Application for a non-material amendment following a grant of planning permission.  
Town and Country Planning Act 1990

Demolition of small side extension.  
Construction of extensions on front and side elevations and internal elevations

DM/2020/00645

Reduction in the width of the side extension  
front door and screen to be recessed to form storm porch

GROUND FLOOR PLAN

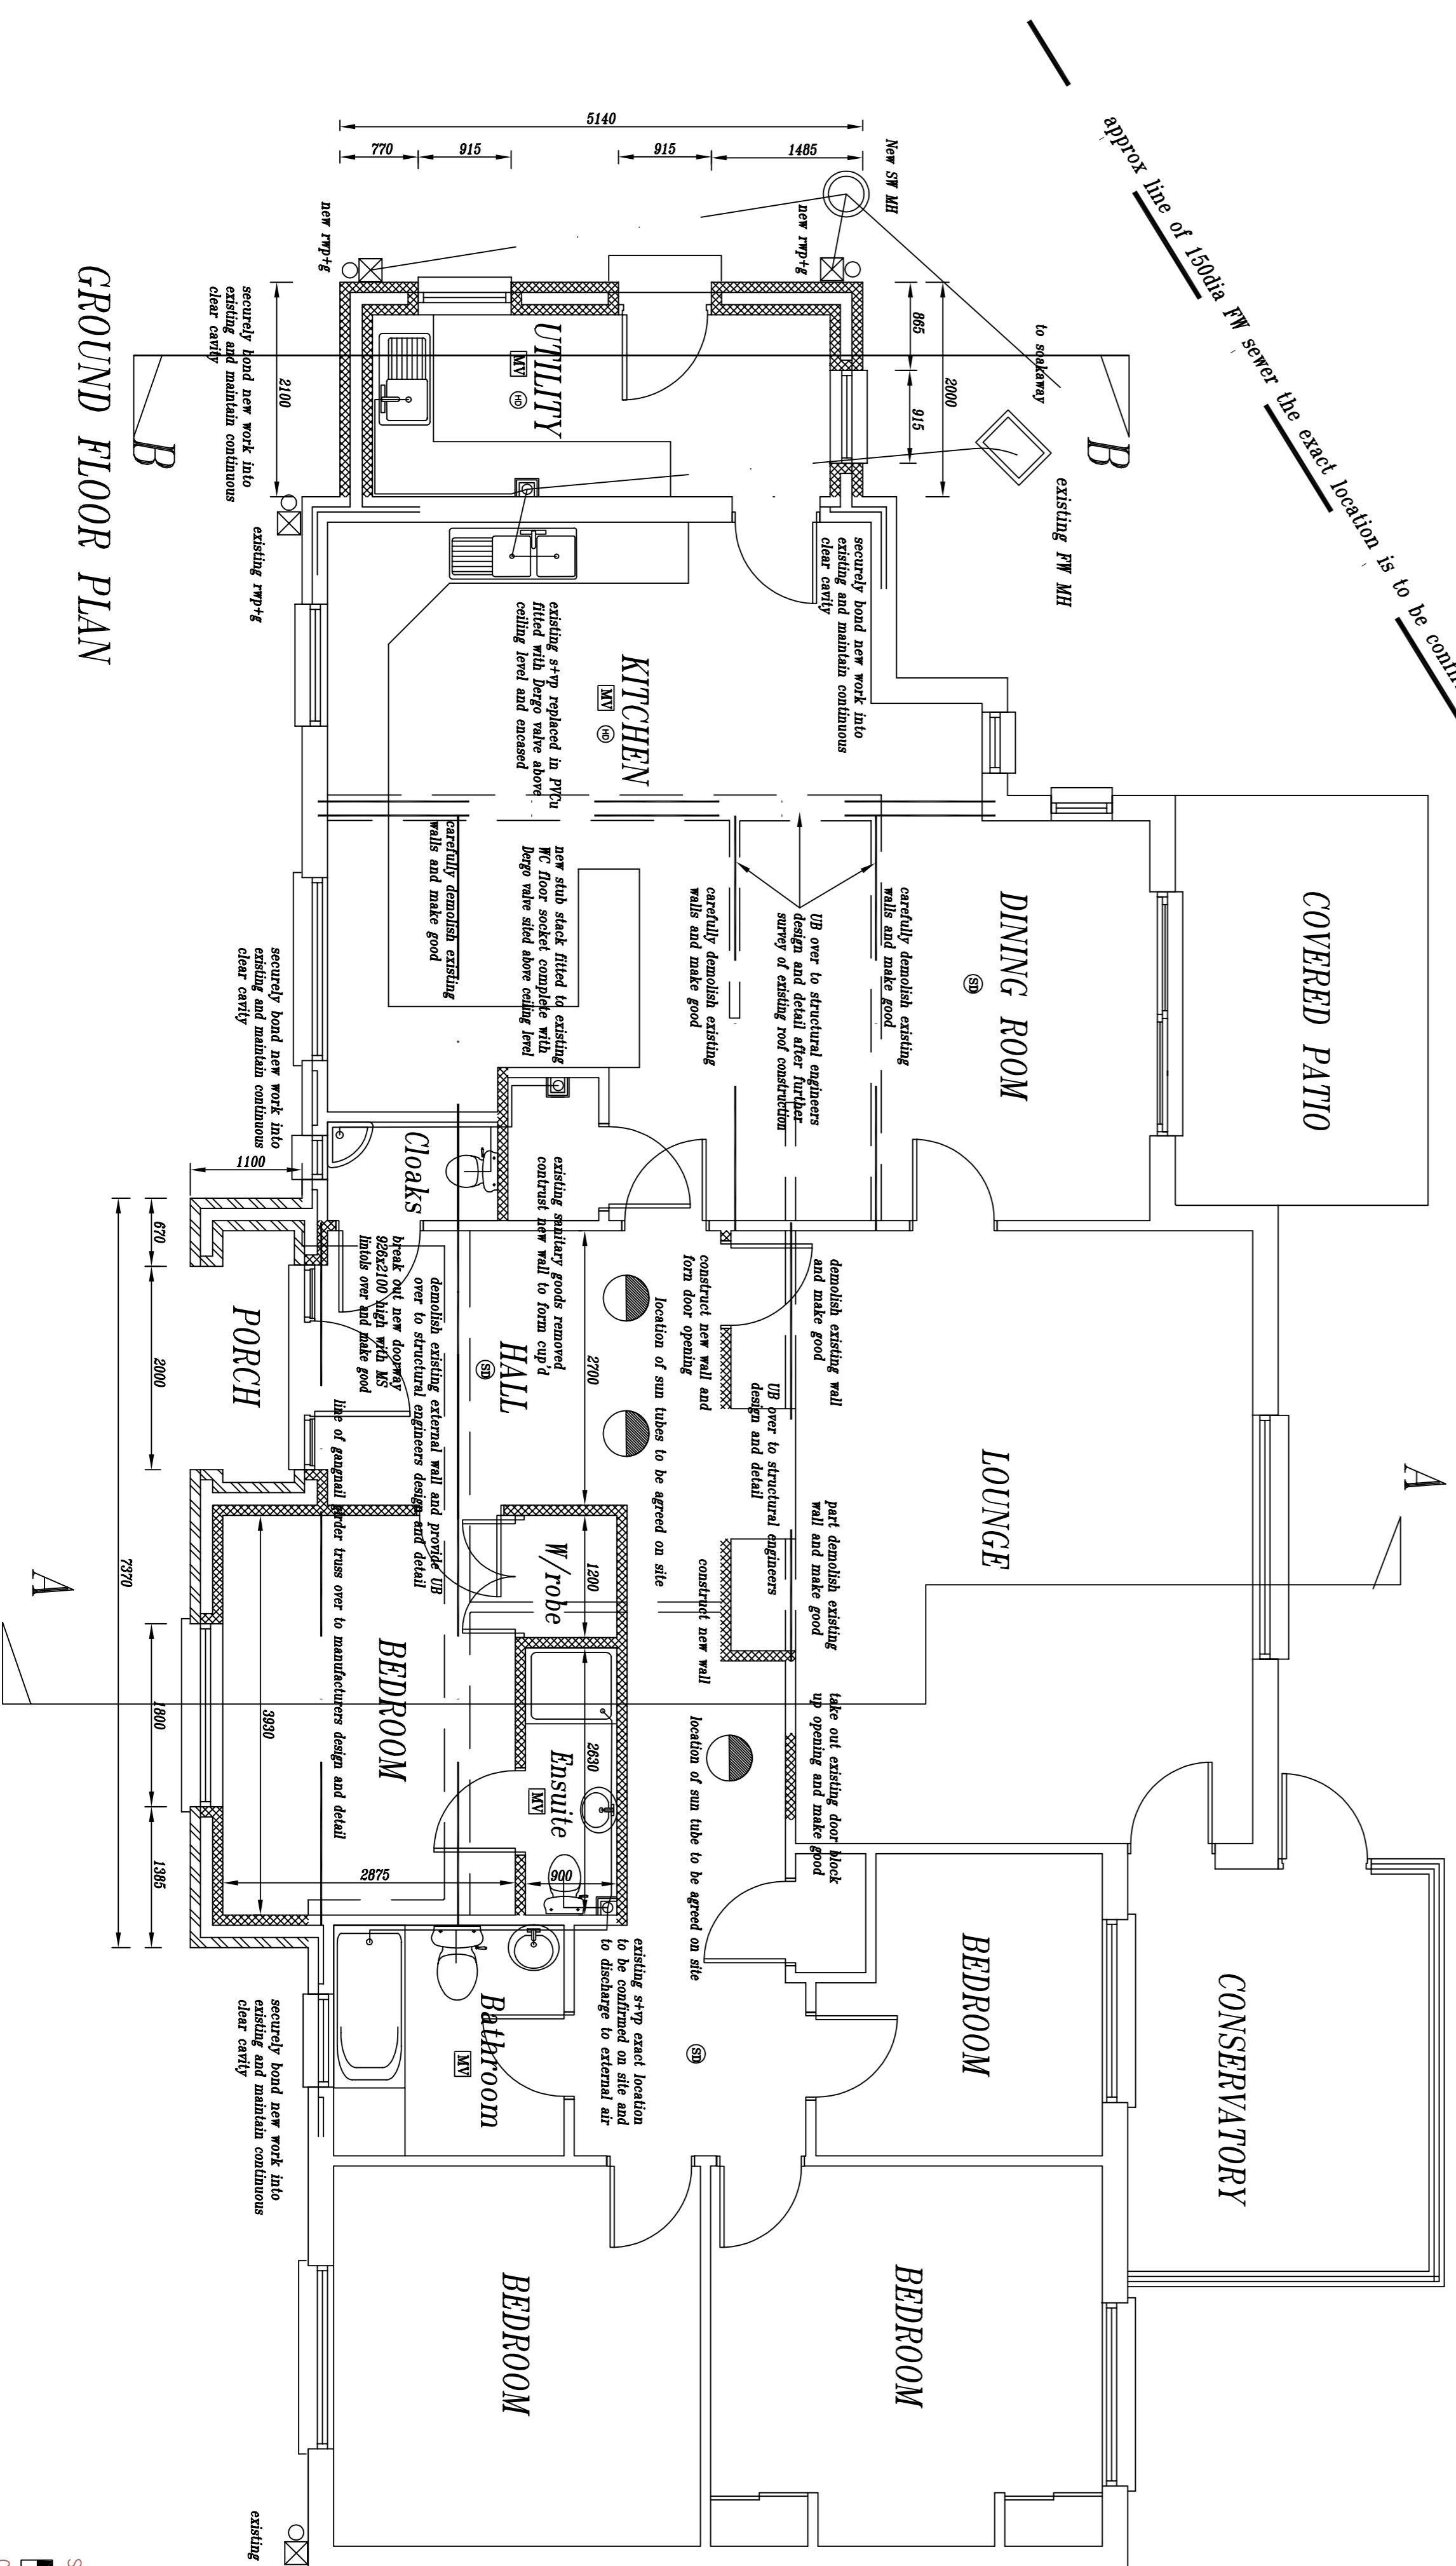
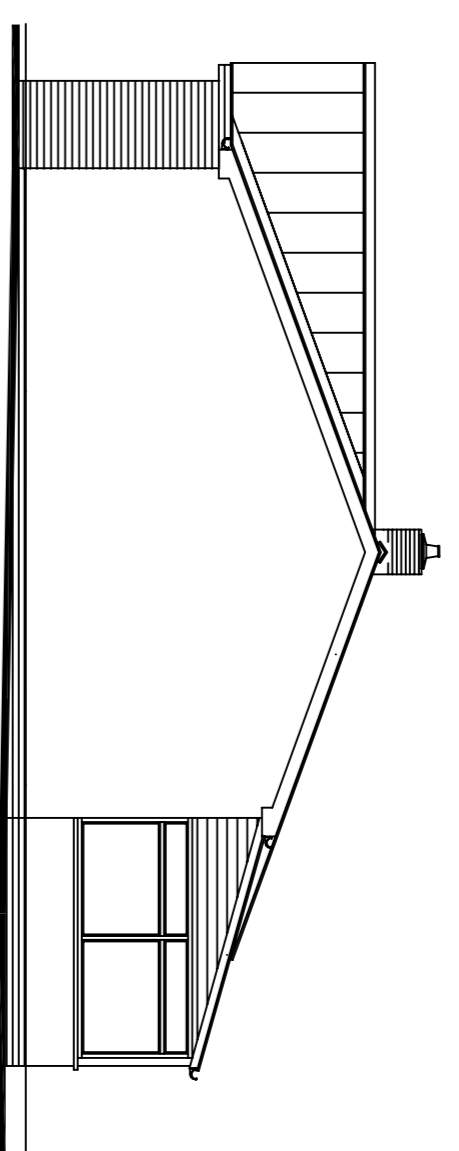
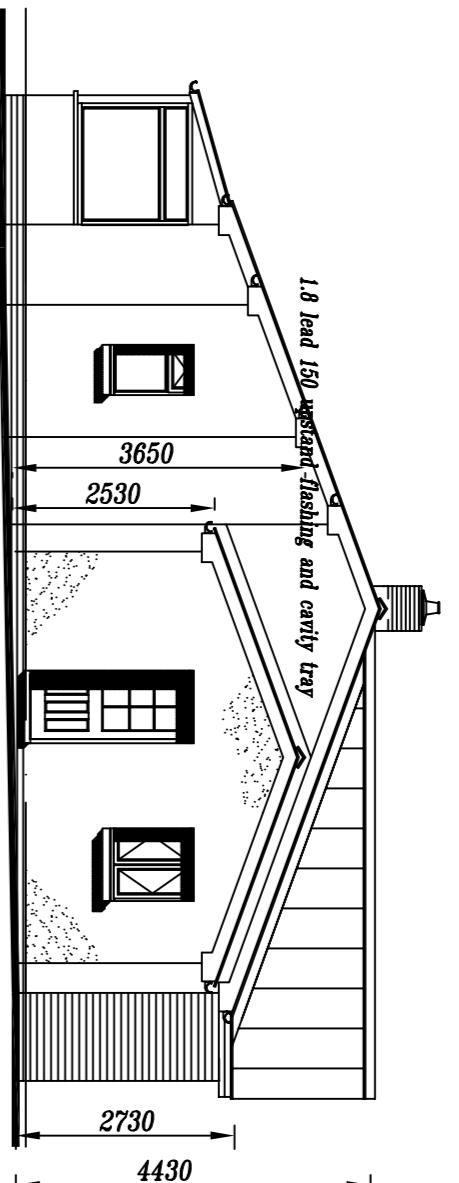
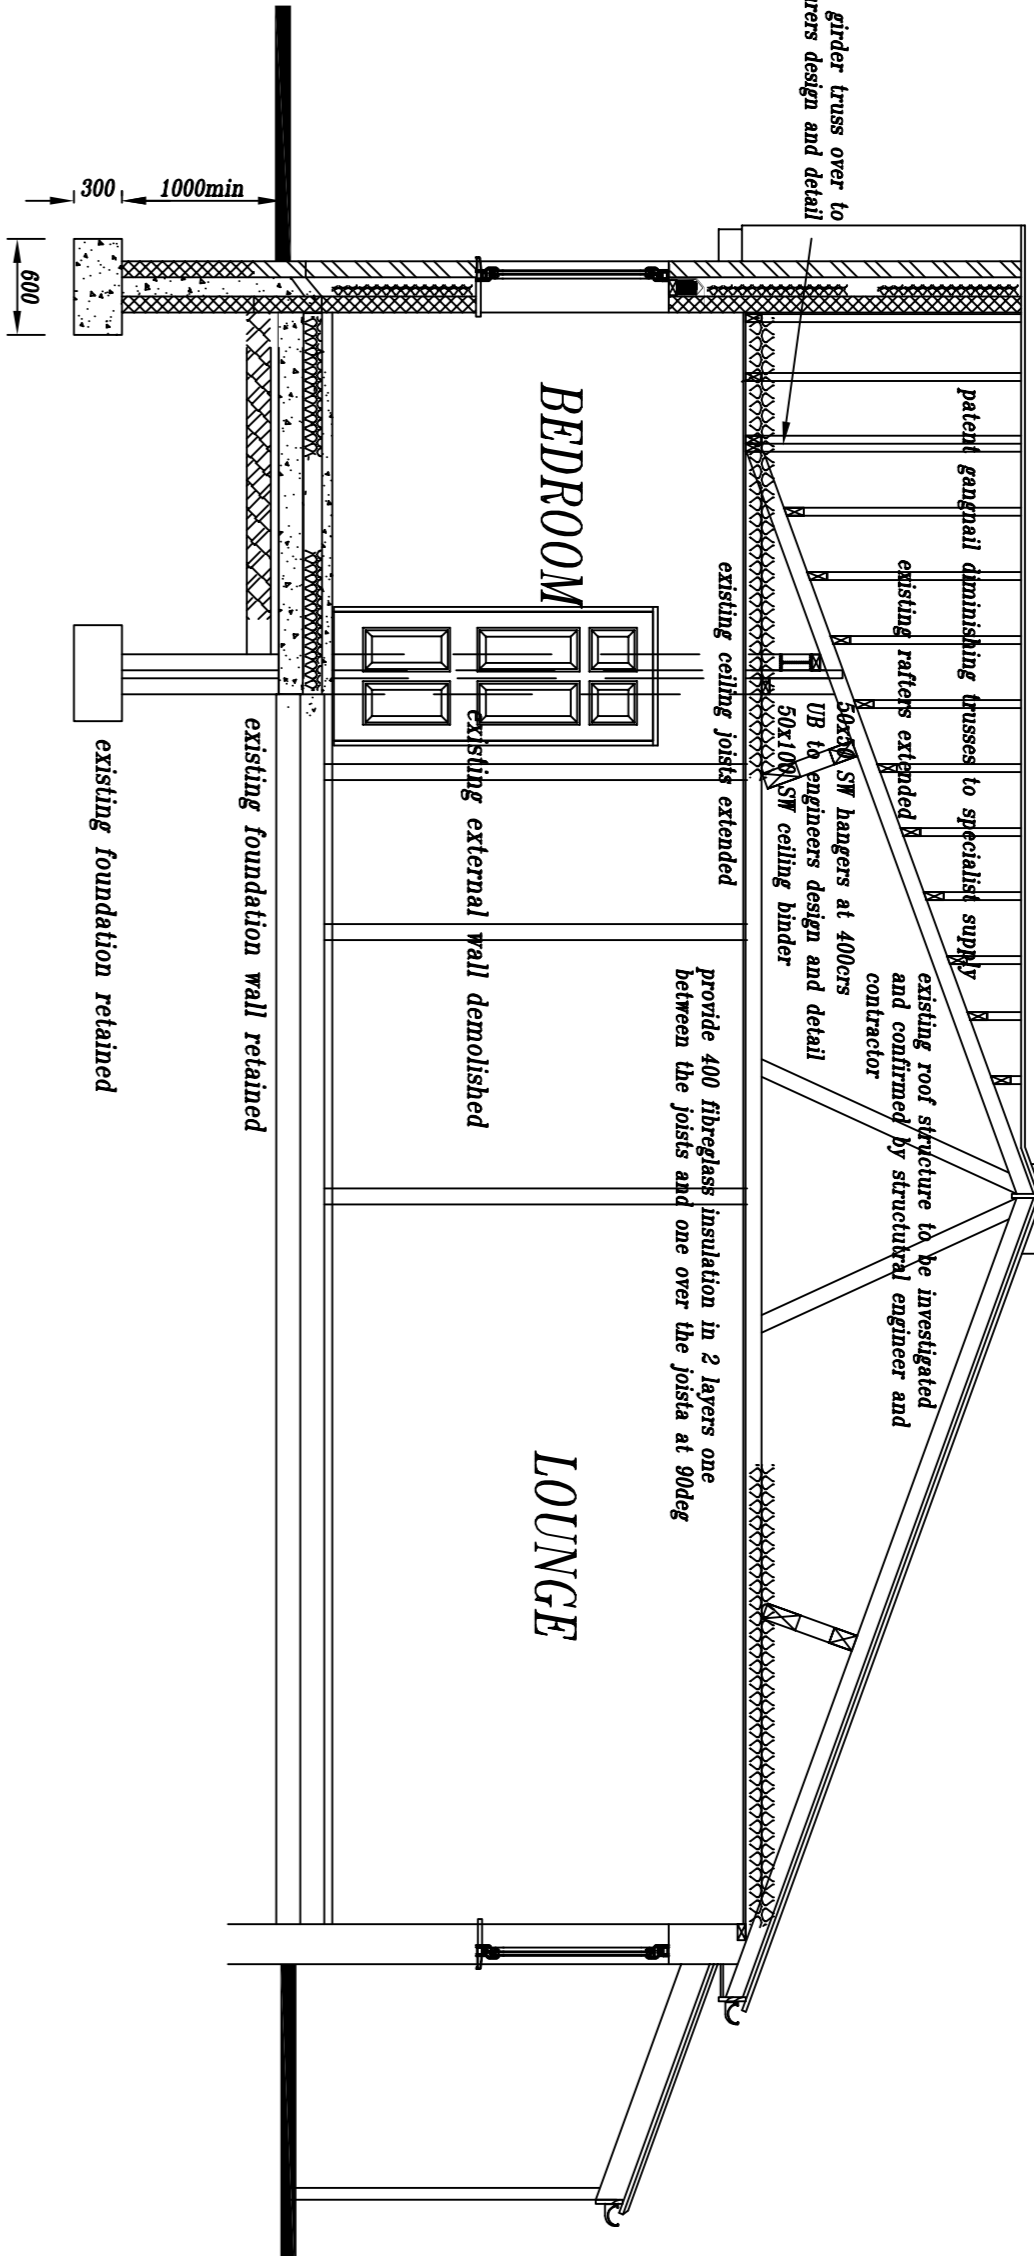
To form a storm porch at the front door and provide additional width to side boundary

1519/1, 2E & 5B (site location plan)
